November 29, 2023
Project No. T-8718

Subject: Response to City of Mercer Island Comments
3036 – 67th Avenue SE
Mercer Island, Washington

11/20/23
JOB NUMBER: **22-042**
SHEET NAME: **DT-01**

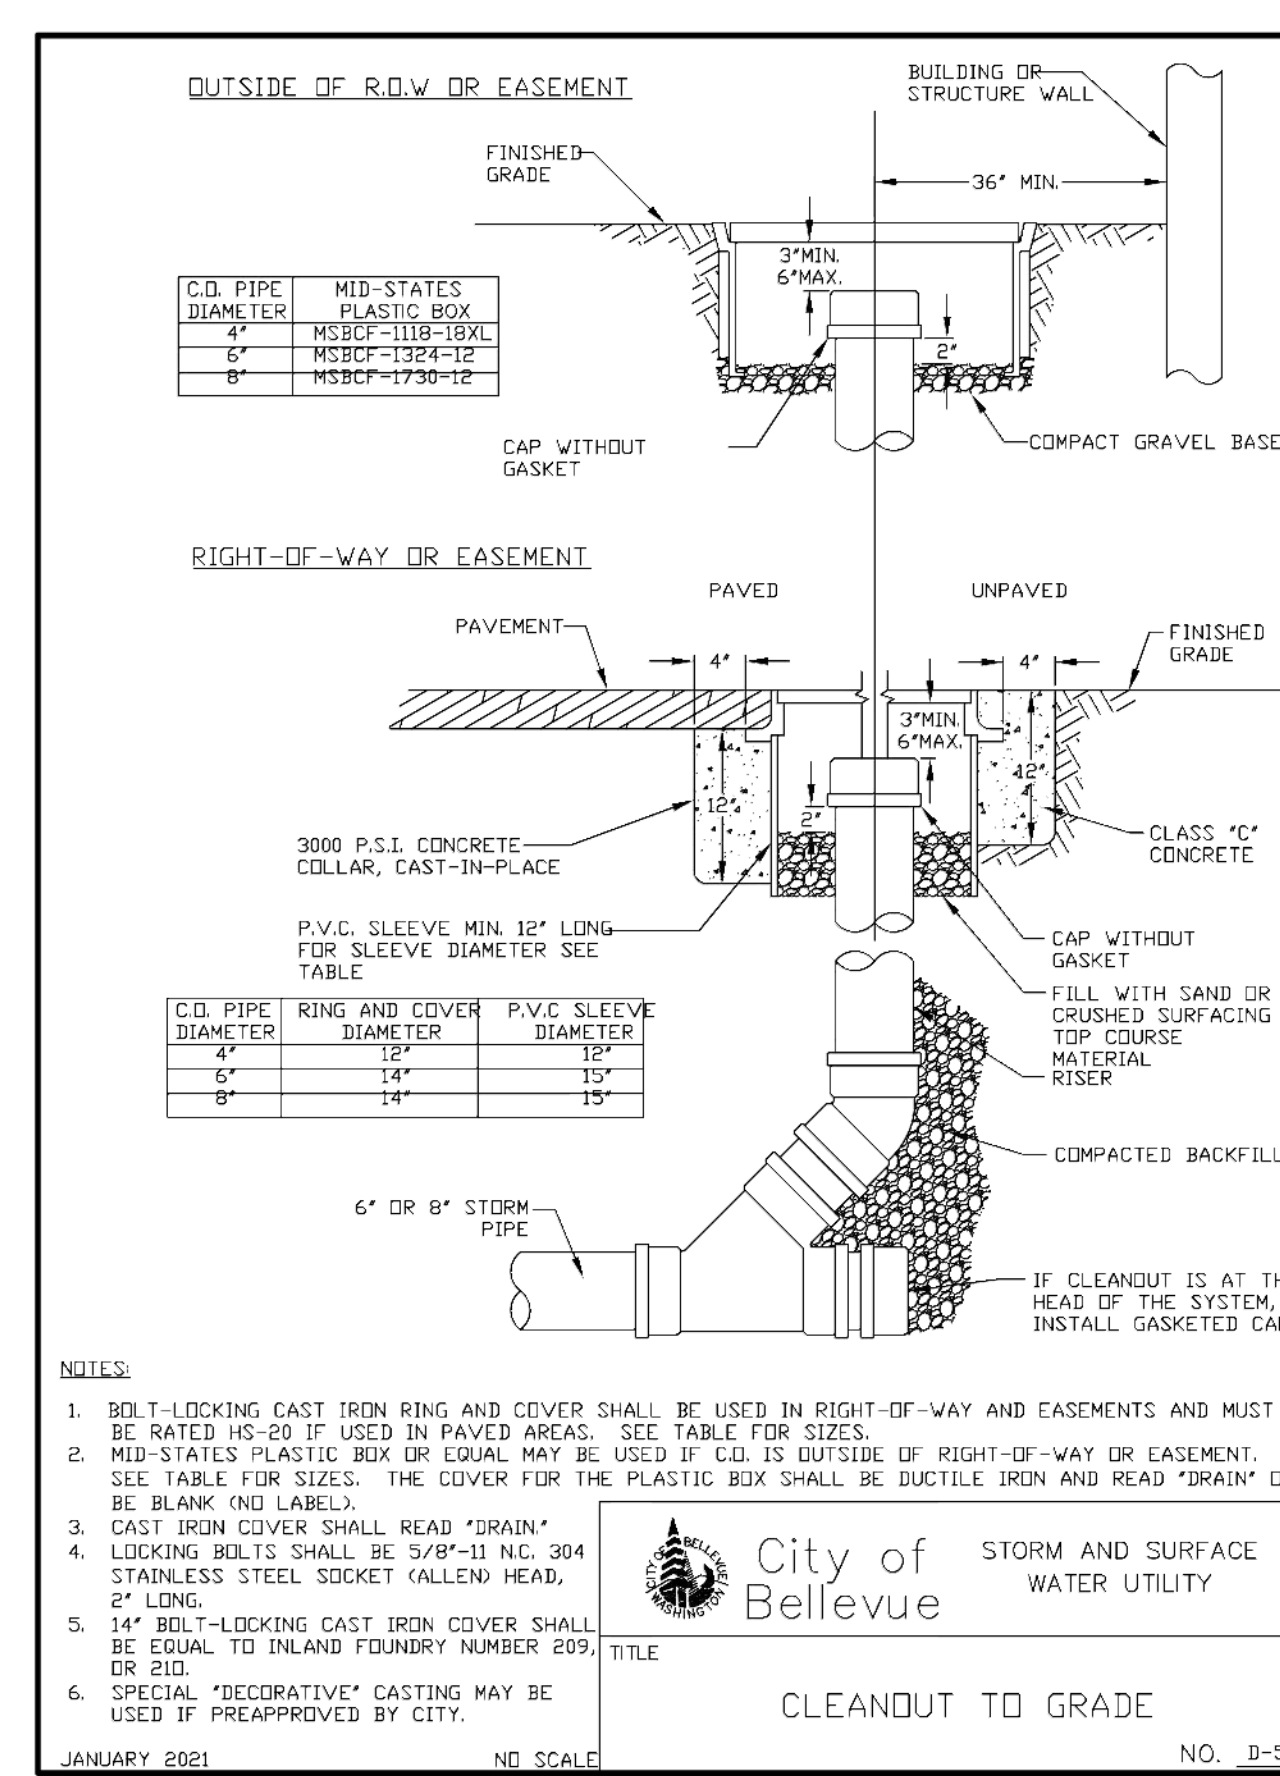
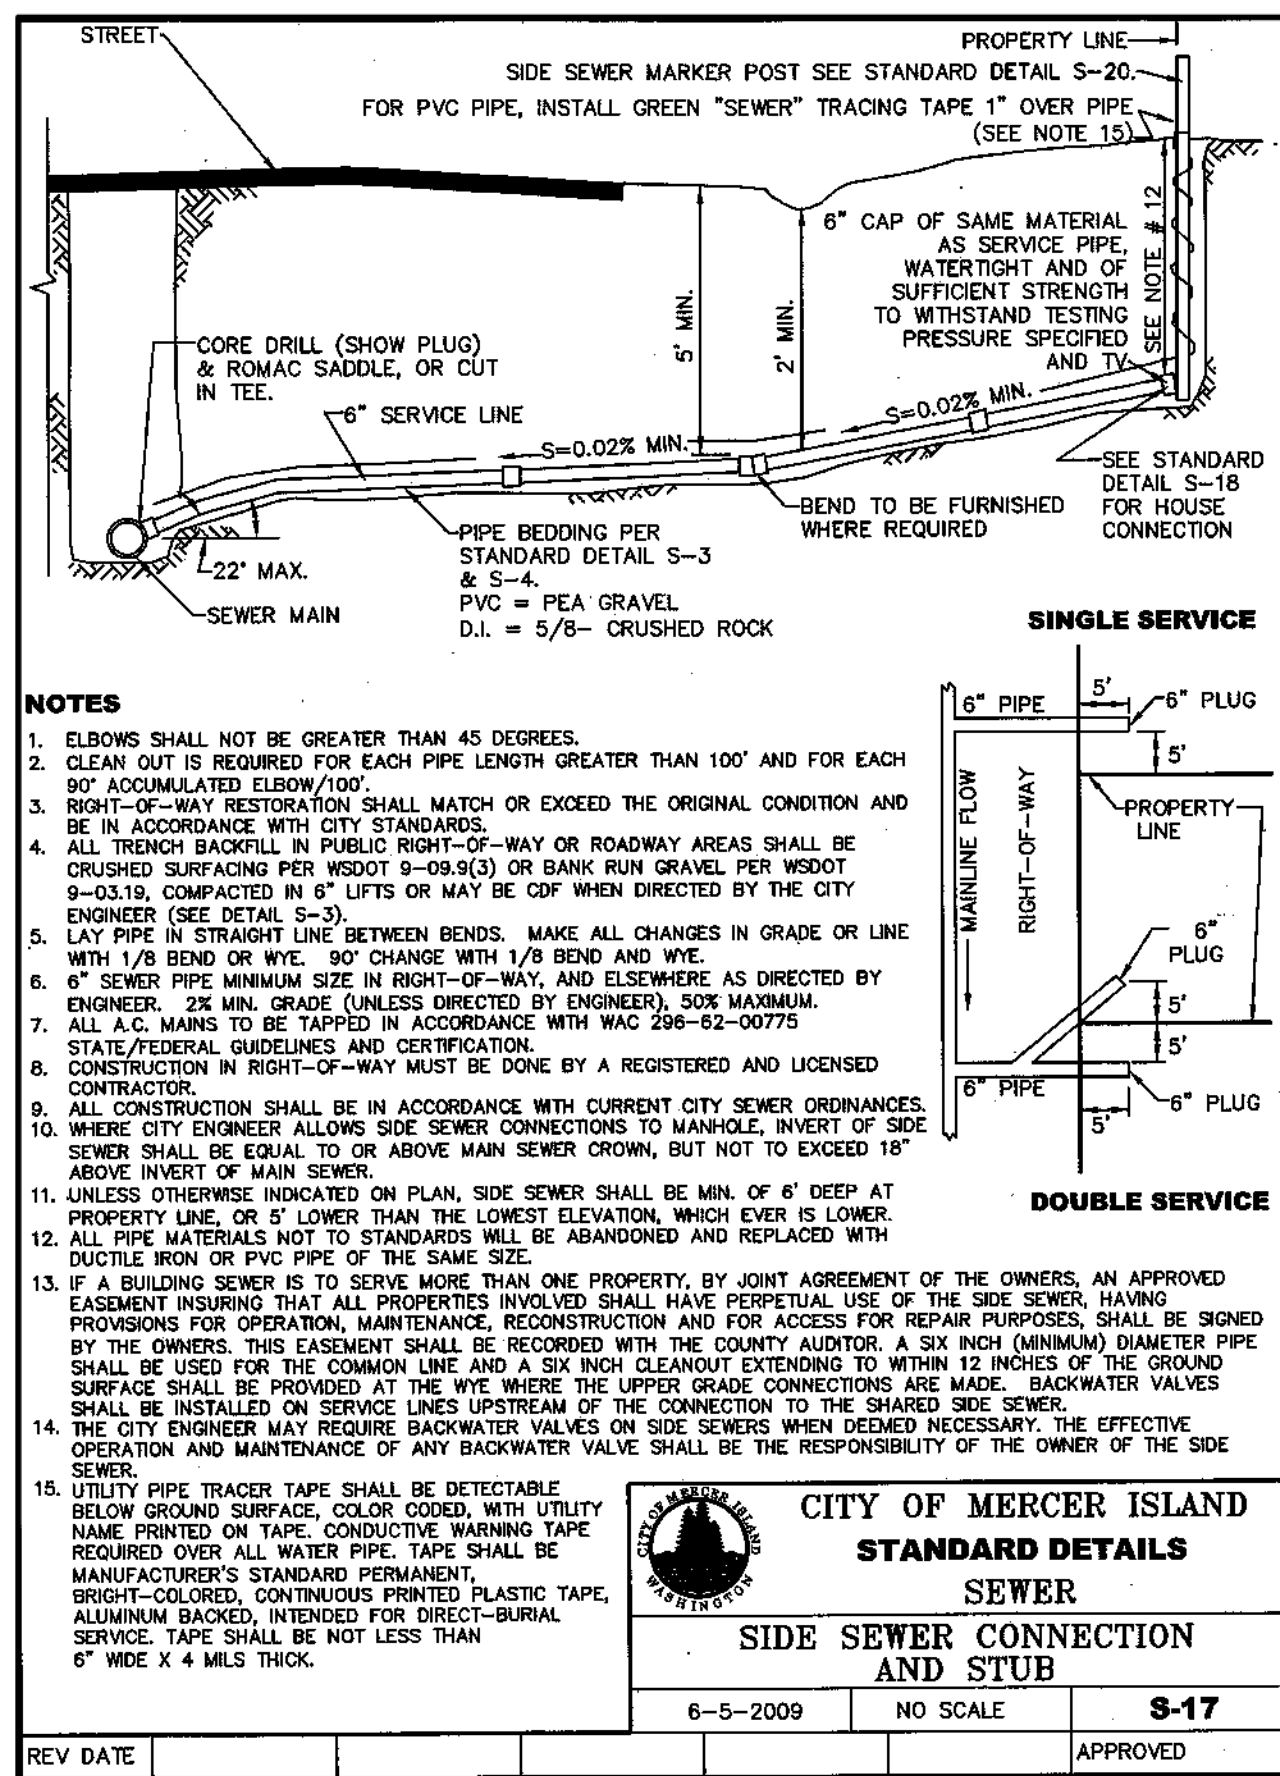
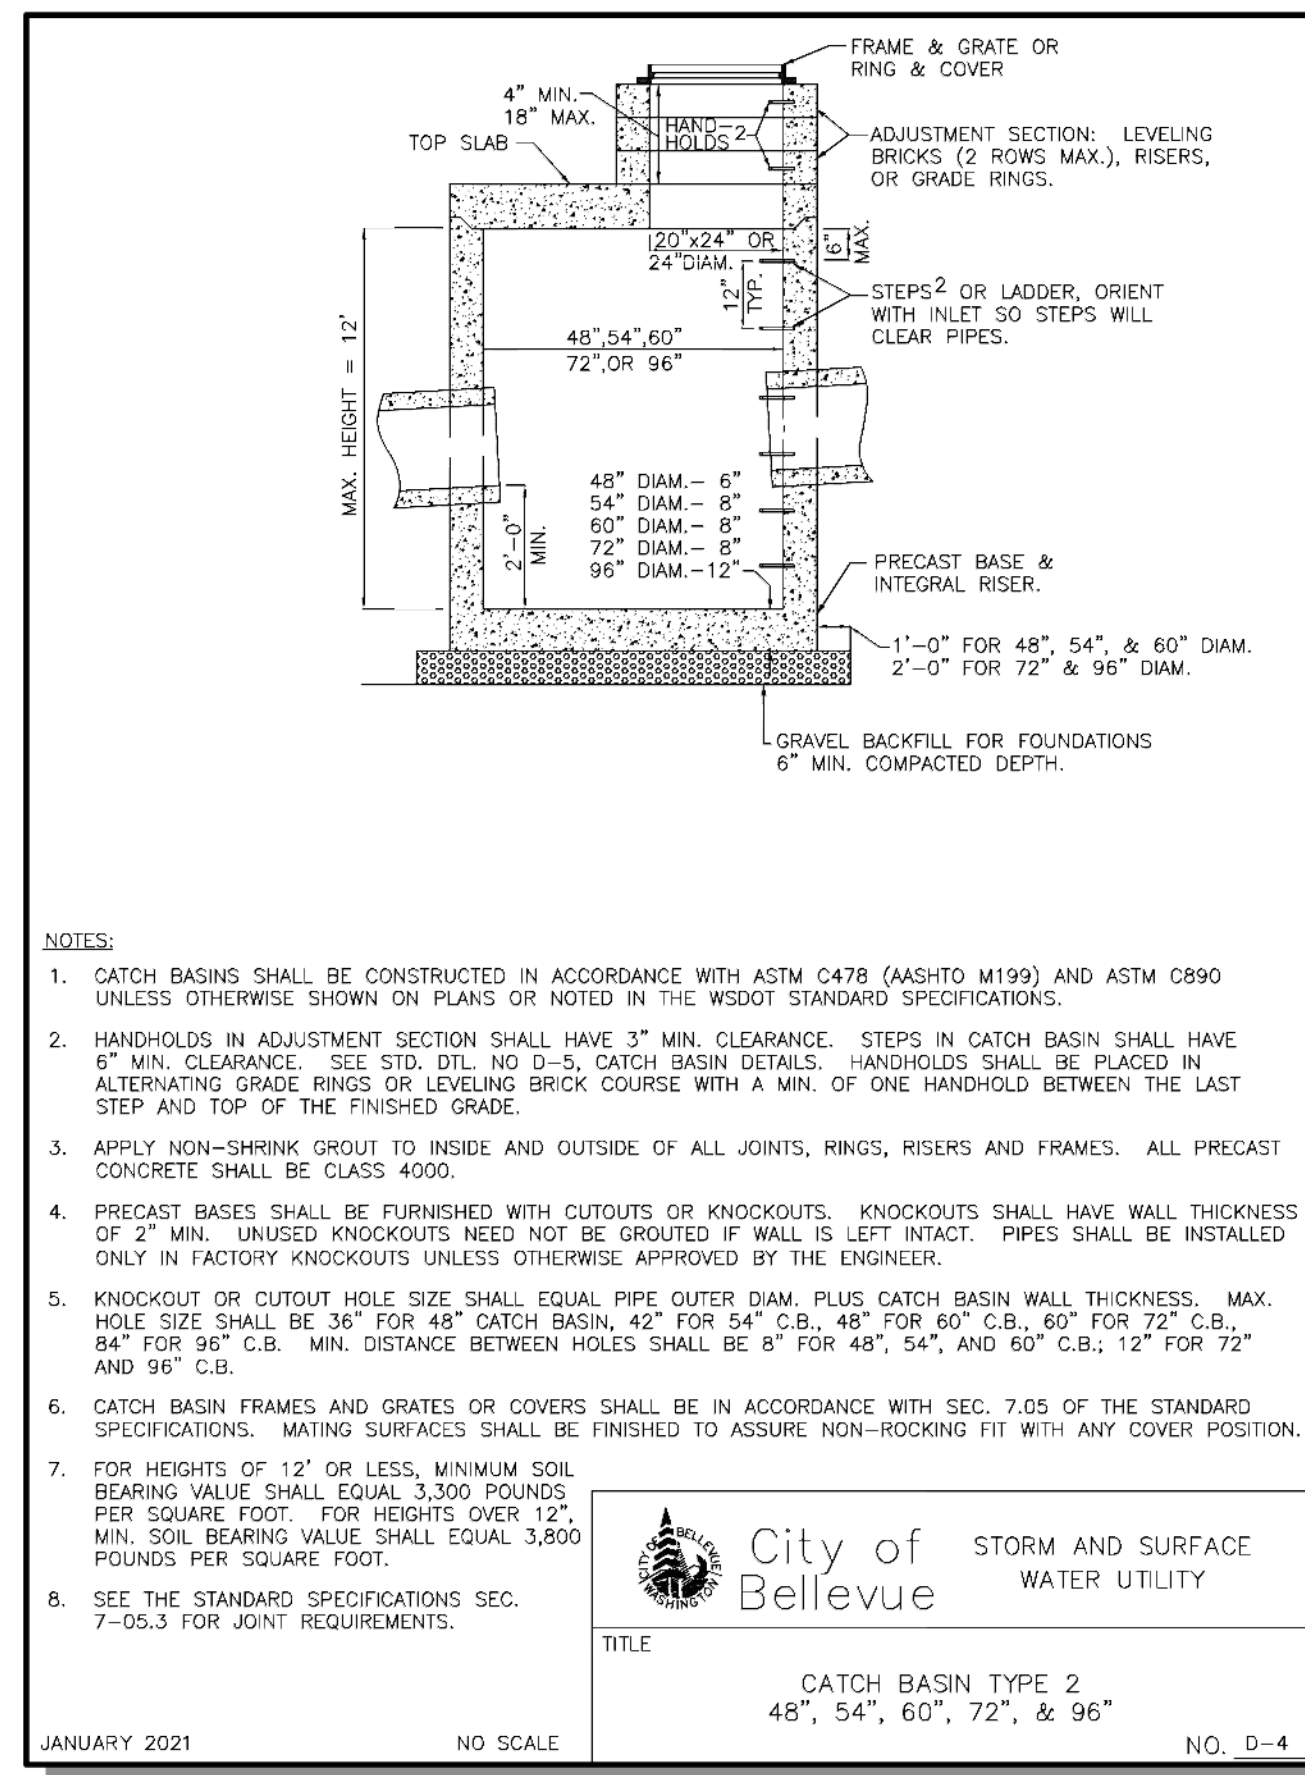
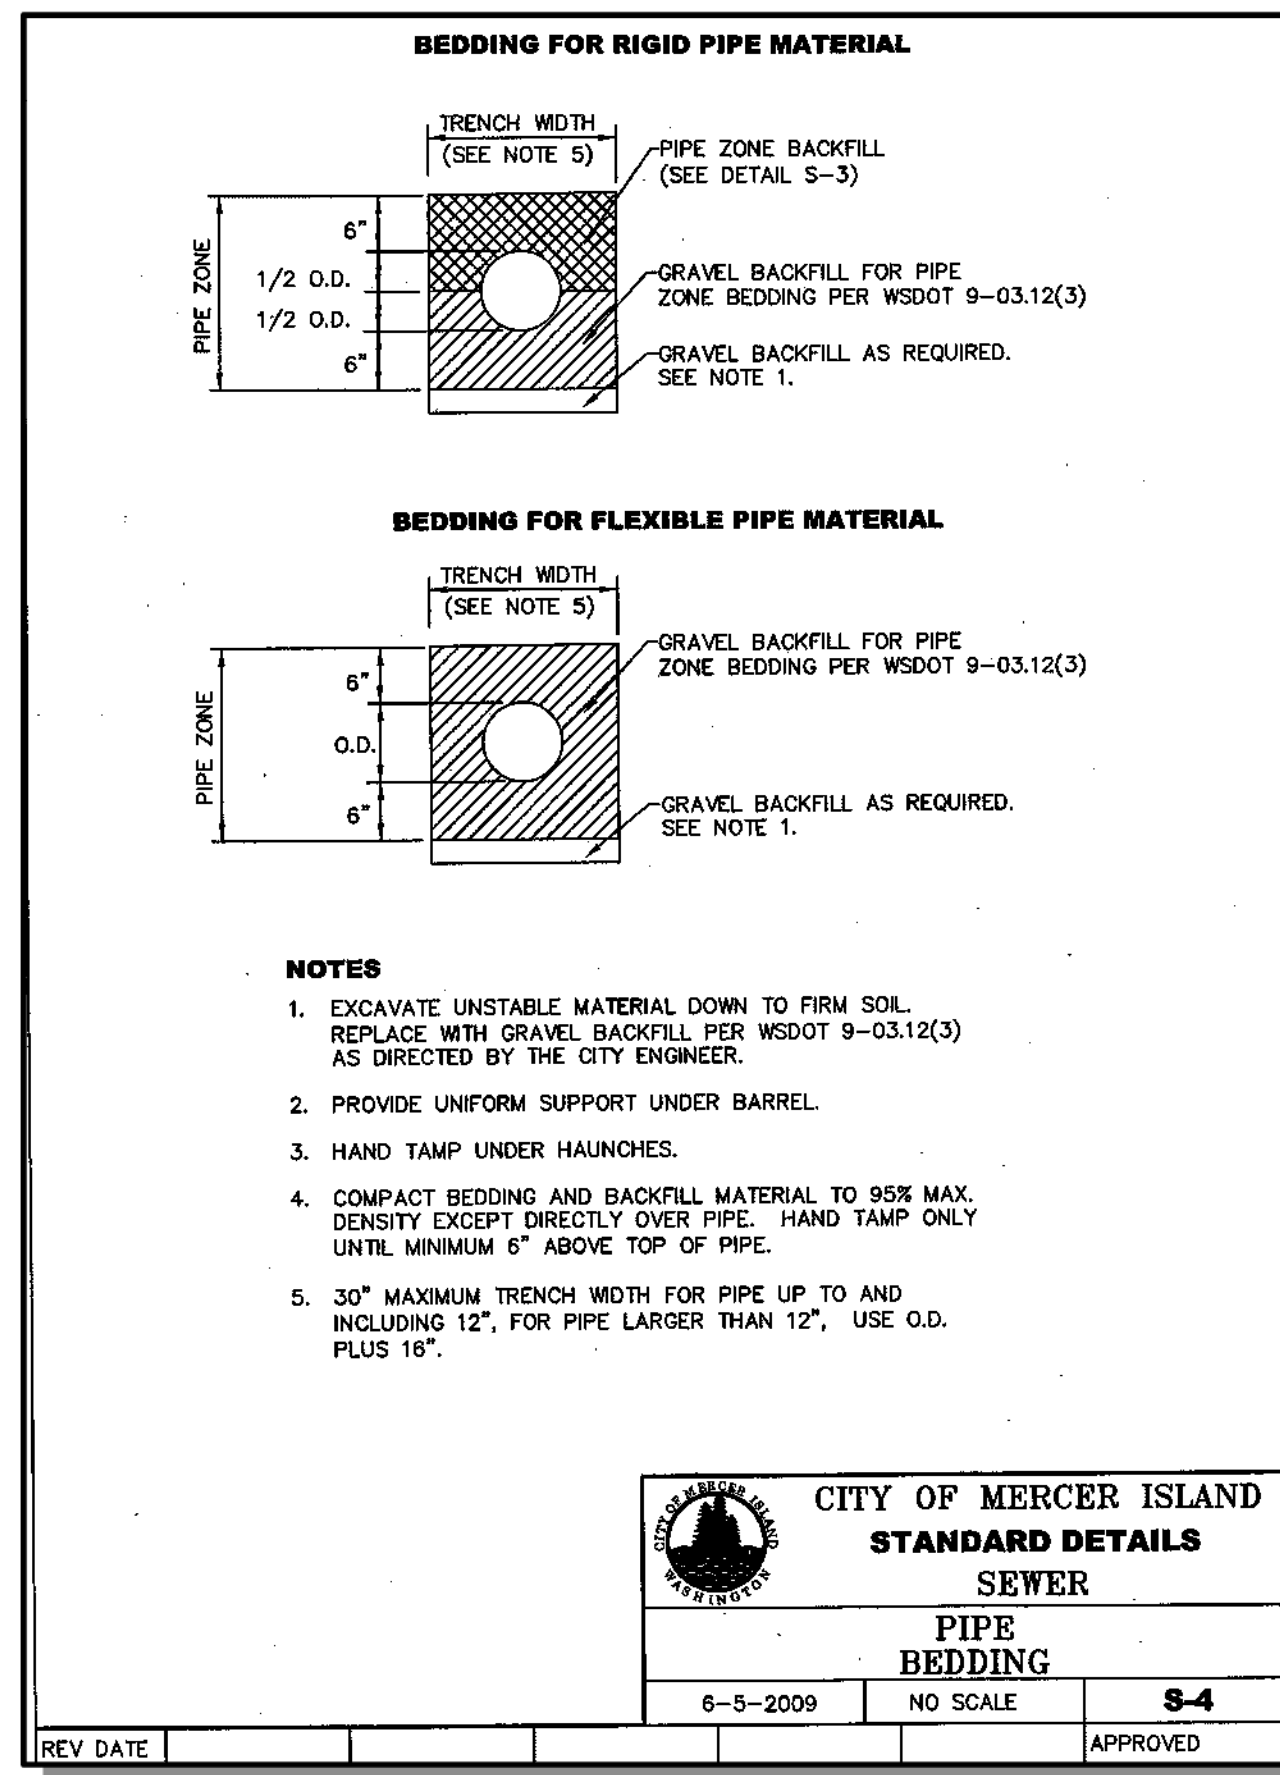
With the SUB5 plan set submission, please provide review letter from geotechnical engineer of record and updated statement of risk.

As requested, we have reviewed Sheets S-0.0 and S-0.1 prepared by Mulhern+Kulp dated November 27, 2023, Sheets A1.1, A2, A8, and D1 prepared by Architectural Innovations, P.S, dated November 27, 2023, and Sheets SP-01, TG-01, and DT-01 prepared by Atwell dated November 20, 2023. Based on our review, the project consists of developing the site with a new single-family residence, associated access, and utilities. The plans indicate the residence will be a three-story, wood-framed structure with an attached garage constructed at grade. An interceptor trench will be installed on the east side of the site with a bottom elevation of 95.70 feet.
